**EL PASO COUNTY PLANNING AND  
 COMMUNITY DEVELOPMENT  
 DEPARTMENT**

**STORMWATER MANAGEMENT PLAN CHECKLIST**

~~PPR 000~~ PPR2111

GRADING & EROSION CONTROL PLAN
CLAREMONT BUSINESS PARK 2 FIL. NO. 1 - LOT 3
JOB NO. 44-037
DATE PREPARED: FEBRUARY 15, 2021
DATE REVISED:

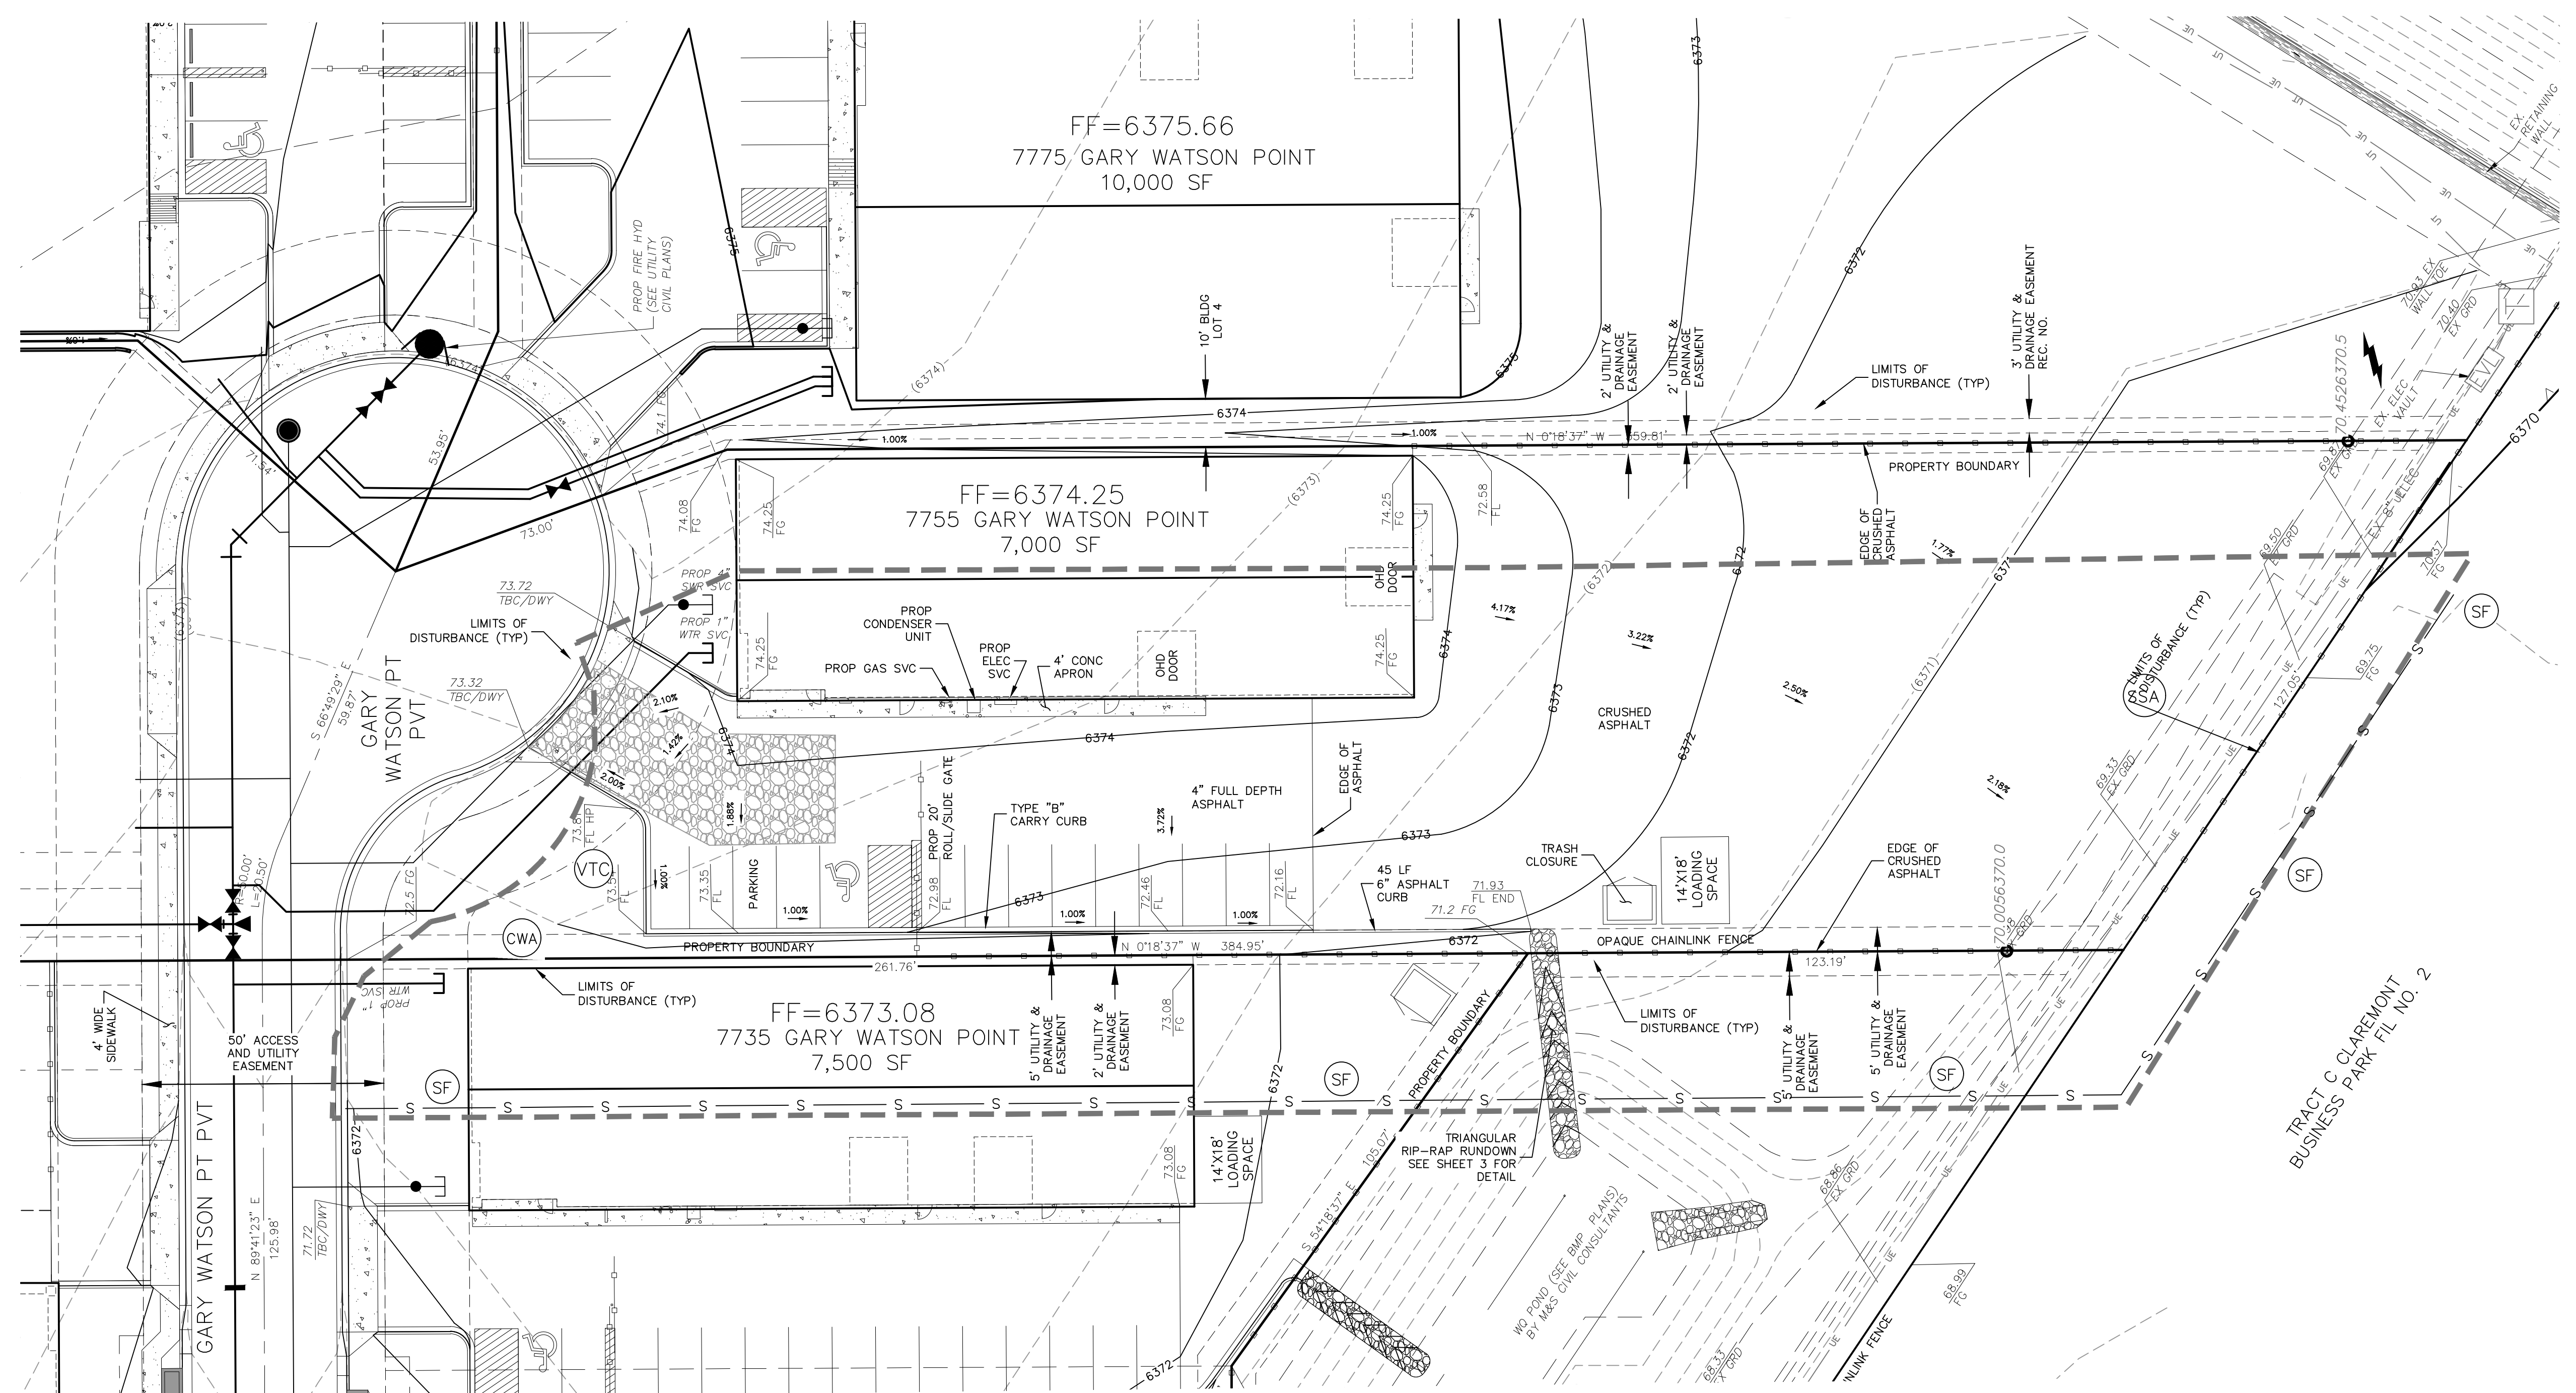
| Revised: July 2019  |  | Applicant | PCD |
|---|--|-----------|-----|
| 17d   | areas of cut and fill  |           | X   |
| 17f   | location of any dedicated asphalt / concrete batch plants  | N/A       | X   |
| 17h   | location of all non-structural control measures  | X         | X   |
| 17i   | springs, streams, wetlands and other surface waters, including areas that require maintenance of pre-existing vegetation within 50 feet of a receiving water   | X         | X   |
